Recommendation Report for Planning Permission for Works or Extension to a Dwelling

REF NO: BE/38/20/HH

LOCATION: Bersted Manor
350 Chichester Road
Bersted
PO21 5BX

PROPOSAL: Demolition of existing open porch and construction of new extension to provide an enclosed porch and accessible WC.

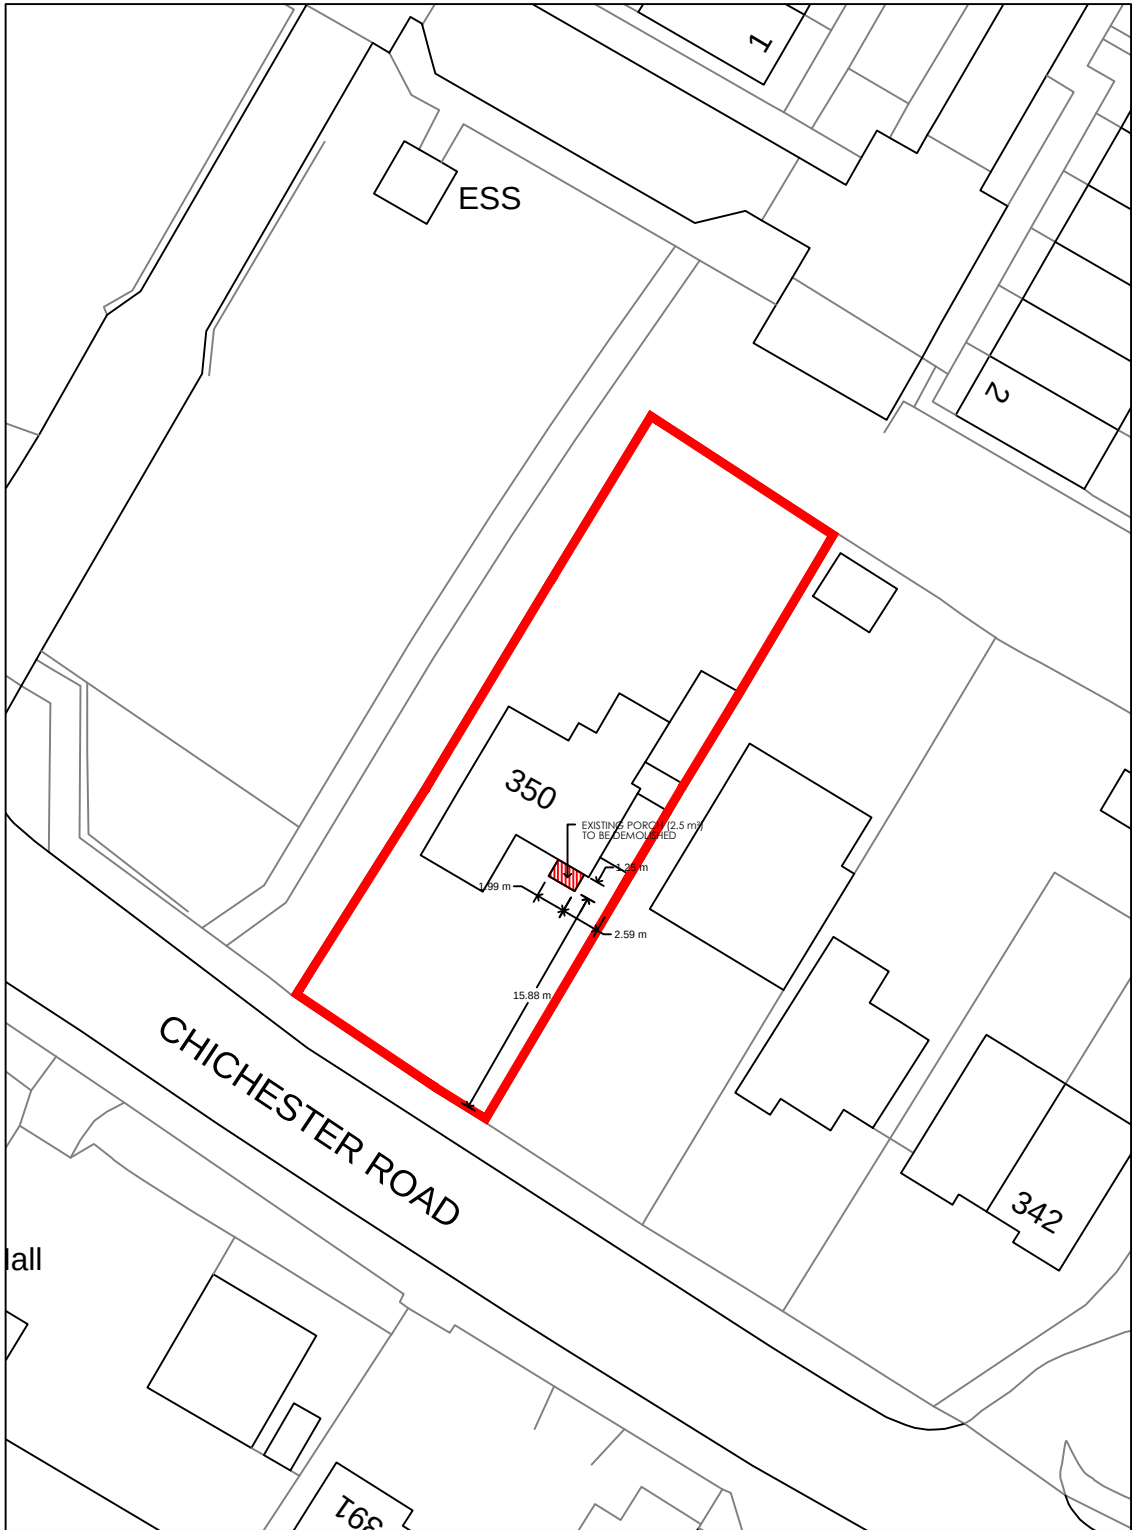
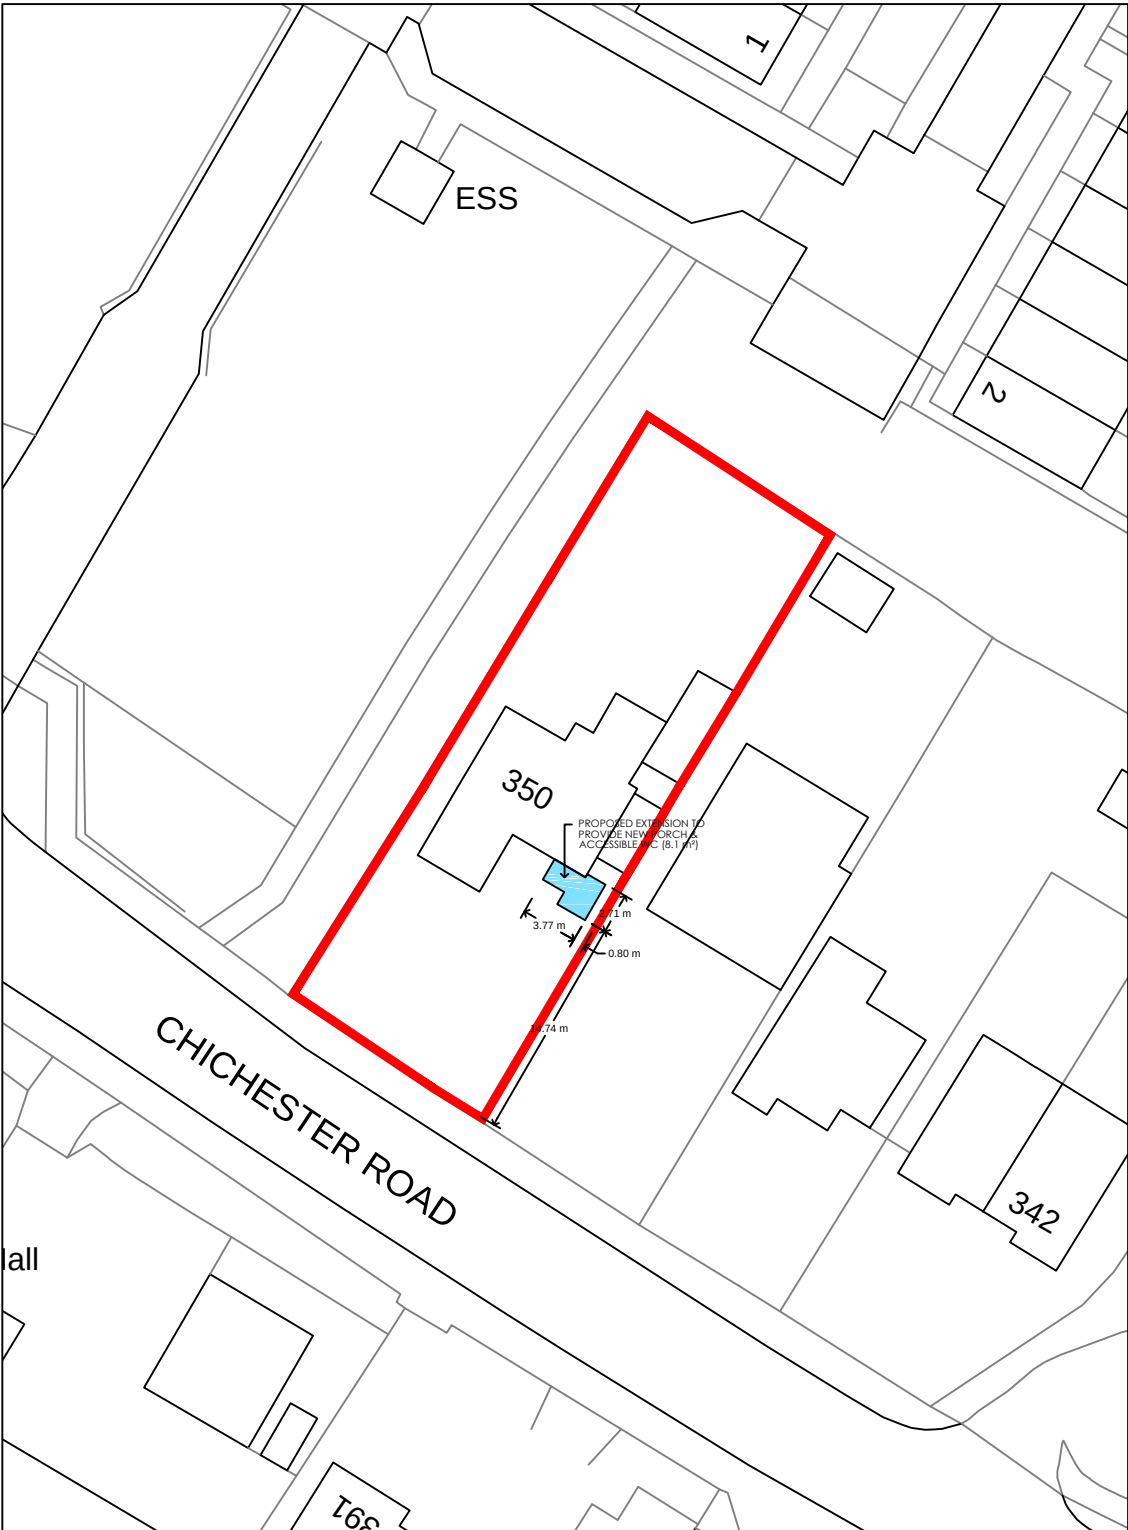
The extension will have a depth of 2.7m, although due to its siting with 14.75m retained to the front boundary, it is not considered to appear unduly dominant upon the front elevation of the property.

The dwelling has an existing front addition which extends beyond that of the proposed and therefore the development does not extend beyond the principle elevation of the dwelling or that of established development line in the area.

Drawing Title
PROPOSED SOUTH & EAST ELEVATIONS

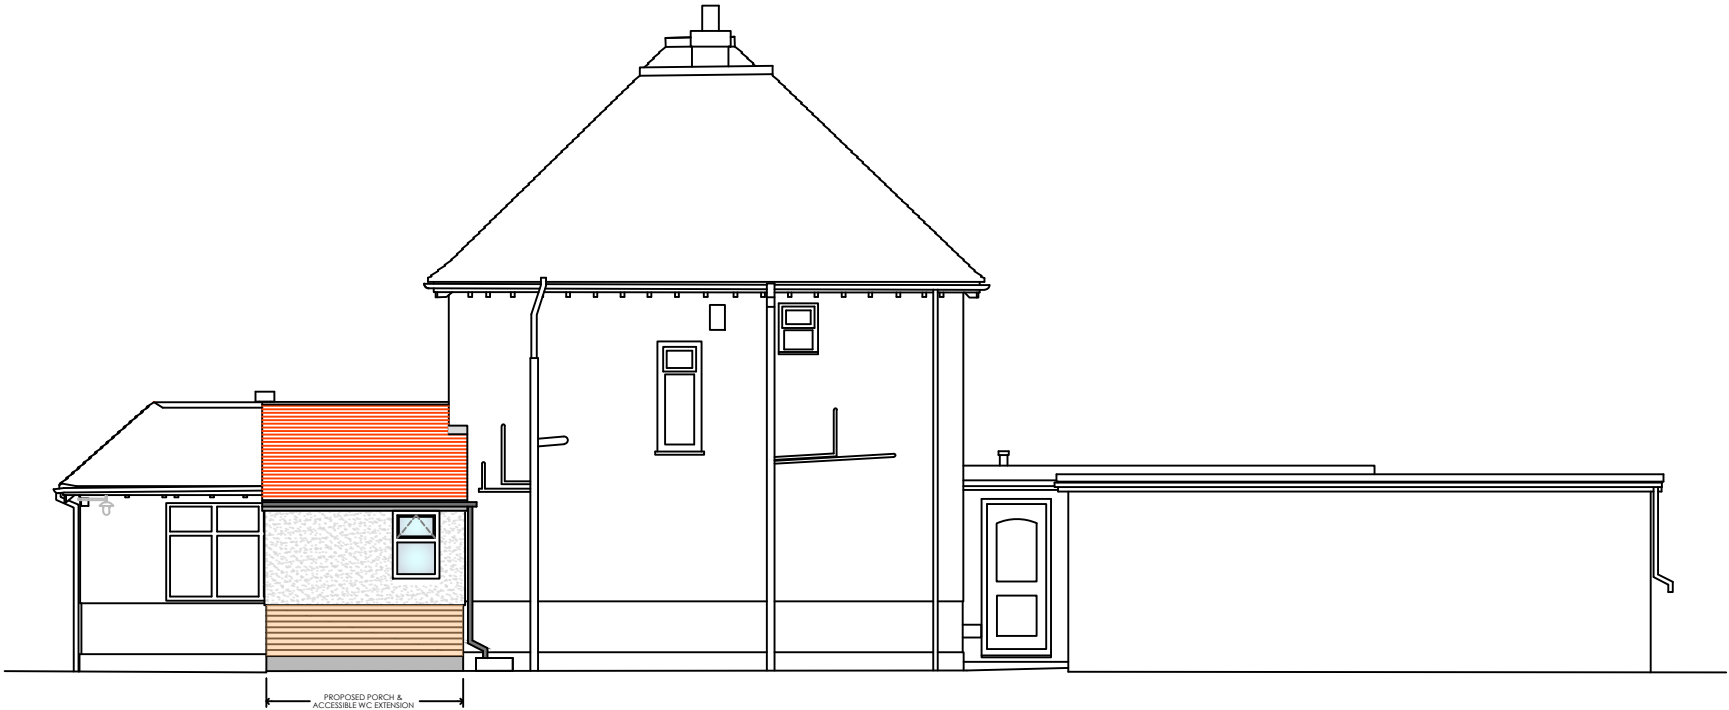
The porch will have a height of 3.6m and a width of 3.4m. This retains around 0.8m to the eastern boundary. There is however high level hedging which restricts the view of the development and as such it is not considered to appear adversely overbearing or overshadowing upon amenity to this elevation.

There will be 1 window to the eastern elevation which will serve a bathroom however due to the boundary treatment in place and its siting to the front, it is not deemed to result in views that are not already available.
